APPENDIX A – RESPONSE TO GOVERNMENT AGENCIES AND ORGANISATIONS

SSD 9210 – Proposed Saints Peter and Paul Assyrian Primary School
17-19 Kosovich Place, Cecil Park (Lot 2320 & 2321 DP 1223137)

1 East Elevation
Scale: 1:200

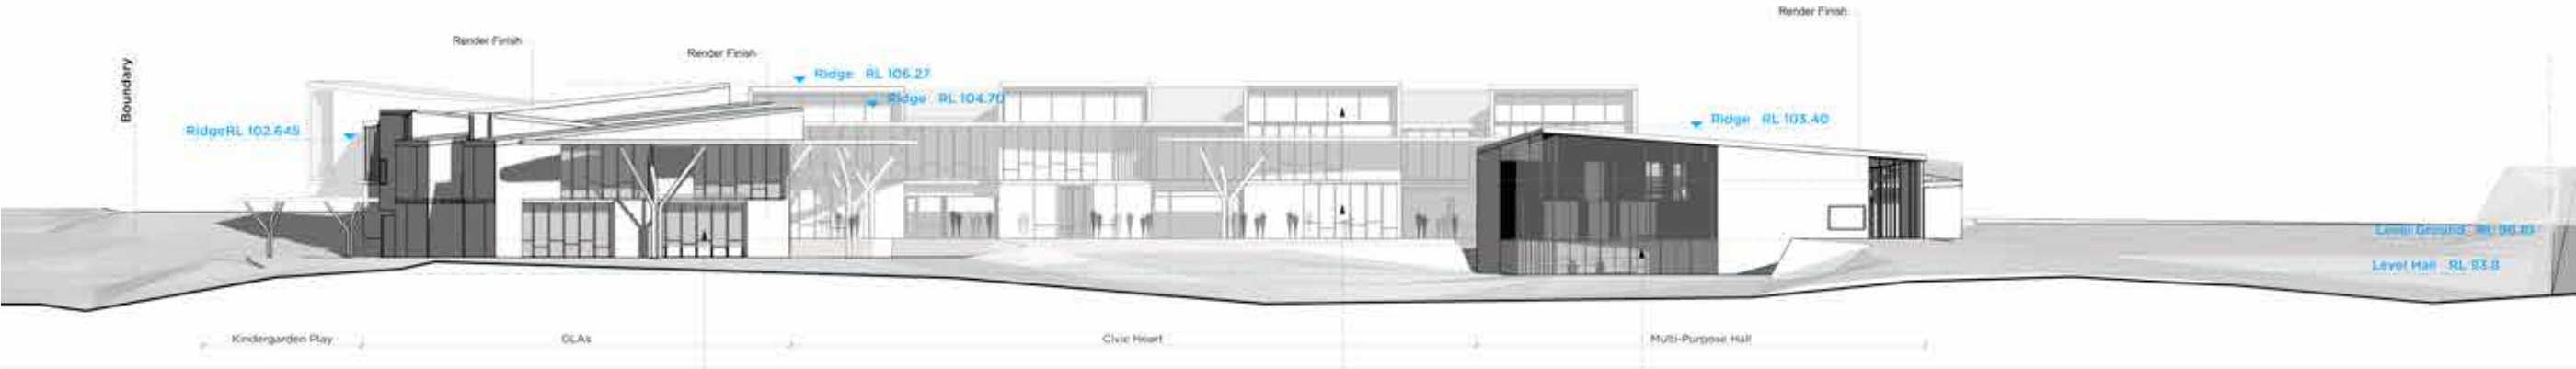
Planning	
Concern is raised that the proposed building design being a single mass, located in close proximity to the eastern boundary, is not considered to be in character with the rural locality. It is noted that the eastern elevation of the building is approximately	The consolidation of internal learning areas and other internal facilities within a single, two (2) storey built form enables unbuilt-upon area and landscaping to be maximised over the site. Through the provision of vast open spaces and extensive landscaping, the site responds to its rural surrounds and maintains a 'green' and vegetated character.

<i>Issues Raised by Agencies and Organisations</i>	<i>Proponent's Response</i>
<p>74.8m in length which is vastly different from the other built forms within the area.</p> <p>Accordingly, the proposal would be inconsistent with the objectives of the zone, particularly <i>"To ensure that development is sympathetic to the rural environment and minimises risks from natural and man-made hazards"</i>.</p>	<p>By contrast, the provision of multiple, detached buildings dispersed across the site in an arrangement more typical of older schools which have needed to provide additional facilities over many years to accommodate growth that was not initially planned for, would deplete the available open space and reduce landscaping. Such an approach to the design of the school would contribute to a site characterised by buildings rather than a green landscape, thereby compromising the rural character of the site.</p> <p>Importantly, the design of the school and concentration of built form in the east of the site also responds to site constraints including bushfire, flood, land contamination, the riparian zone and topography. The design and siting of buildings best allows for the continuation of natural processes and maintenance of natural landscapes, whilst also mitigating potential hazards and risks for future school students and staff. This represents an informed approach to planning in a currently rural locality.</p> <p>Additionally, whilst the school incorporates built form that is larger than existing buildings in the immediate area, the overall appearance of the density, bulk and scale of the development has been managed through façade articulation, appropriate massing of different building elements, the equitable treatment of level changes to create appropriate transitions across the grounds, and landscaping to soften the appearance of built form. Façade articulation, which contributes to positive aesthetics and creates a 'human' scale to the development, has been achieved through the application of contrasting render and face brick textures in facades, glazing, appropriate massing of different building elements, clearly defined building entries, modulated canopies and alternating skillion roof forms.</p> <p>With specific reference to the eastern elevation, the appearance of the length and overall scale of the building wall has been mitigated through the articulation of classroom spaces as separate building volumes, varied façade finishes, modulated roof forms, outdoor learning courtyards and boundary landscaping providing 'green screening'. Also of note, the building wall has been setback a minimum of 20m from the eastern side boundary, which significantly exceeds the 5m side setbacks required pursuant</p>

<i>Issues Raised by Agencies and Organisations</i>	<i>Proponent's Response</i>
	<p>to FDCP and offers significant building separation from the adjoining property. Extracts showing the eastern elevation are provided at Figure 1-2 below.</p> <p>Therefore the design of the eastern elevation and eastern boundary setbacks are <i>not</i> considered to be in any way 'inappropriate'.</p> <p>Similarly, the proposal would <i>not</i> be inconsistent with the objectives of the RU4 zone. Council have specifically queried the proposal's consistency with the following zone objective:</p> <p><i>To ensure that development is sympathetic to the rural environment and minimises risks from natural and man-made hazards.</i></p> <p>As described in the above paragraphs, the development is <i>sympathetic to the rural environment</i> on the following basis:</p> <ul style="list-style-type: none">▪ The design integrates with the rural environment through maximising open space, unbuilt-upon area and landscaping over the site.▪ The appearance of the bulk and scale of the built form has been managed through façade articulation, massing of different building envelopes, treatment of level changes, modulated roof forms, setbacks and landscaping.▪ Vegetation planting adjacent to the site boundaries will soften views toward the site, riparian planting will enhance the environmental quality of the corridor in the site's west, and more than half of the site will be retained as open space.▪ Canopy trees proposed to be planted will extend above the height of the roofline, thereby assisting the scale of the development to integrate with its landscape.▪ The amenity of surrounding rural properties has been safeguarded through generous boundary setbacks, extensive landscaping and planting of canopy trees.

**Figure 24. Proposed New Padmount Substation Location (JHA 2018)**

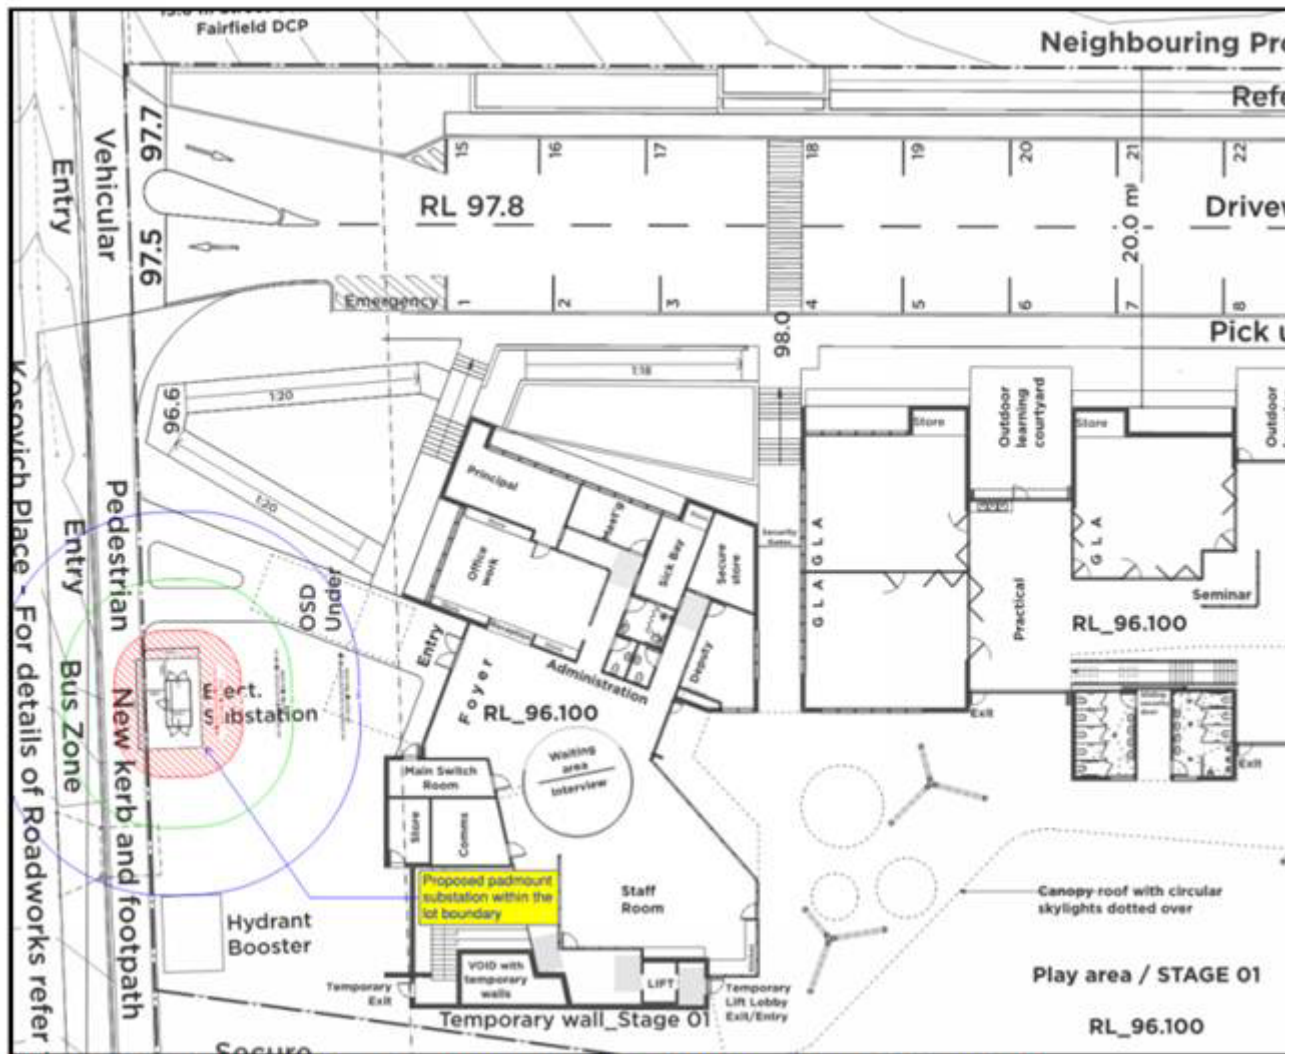
In regards to the existing pole mounted substation no. 25488, these have comparatively limited capacity of 25 kilovolt amperes (kVA) up to a maximum of 400 kVA where as a newer padmount substation can accommodate loads from 315 kVA up to 1,500 kVA ie. there is a significant variation in the number and type of premises able to be connected to a substation. Pole mounted	<p>Noted; the information provided by Endeavour Energy is consistent with the Electrical Infrastructure Assessment prepared by JHA Consulting Engineers and provided at Appendix 31 of the original SSDA. As described in the Electrical Infrastructure Assessment, a new padmount substation is proposed to provide the electricity supply required for the school.</p>

<p>In regards to the future padmount substation required for the site, please find attached for the applicant's reference a copy of Endeavour Energy's 'Guide to Fencing, Retaining Walls and Maintenance Around Padmount Substations'.</p>	<p>The design of structures, and ongoing maintenance, around the padmount station will comply with Endeavour Energy's 'Guide to Fencing, Retaining Walls and Maintenance Around Padmount Substations'.</p>

<i>Issues Raised by Agencies and Organisations</i>	<i>Proponent's Response</i>
substation no. 25488 currently has 5 customer connection points servicing 6 premises and is not intended to or capable of supplying a significant urban development of this nature.	
In regards to the easement and restrictions required for the padmount substation, please refer to the attached copy of Endeavour Energy's <i>Mains Design Instruction MDI 0044 'Easements and Property Tenure Rights'</i> .	The easements and restrictions required for electricity purposes will be registered on Title.
<i>Street Lighting</i>	
<p>With the significant increase in both vehicular and pedestrian traffic, given the existing streetlighting is designed for a non-urban environment, the streetlighting for the proposed development should be reviewed and if necessary upgraded to comply with the series of standards applying to the lighting of roads and public spaces set out in with Australian/New Zealand Standard AS/NZS 1158: 2010 'Lighting for roads and public spaces' as updated from time to time.</p> <p>Whilst the determination of the appropriate lighting rests with the road controlling authority, Endeavour Energy as a Public Lighting Service Provider is responsible for operating and maintaining the streetlights on behalf of local</p>	The existing street lighting will most likely need to be upgraded. If the authorities determine that the lighting does need to be upgraded, ongoing consultation with the relevant authorities will be carried out to ensure the design of lighting meets relevant requirements.
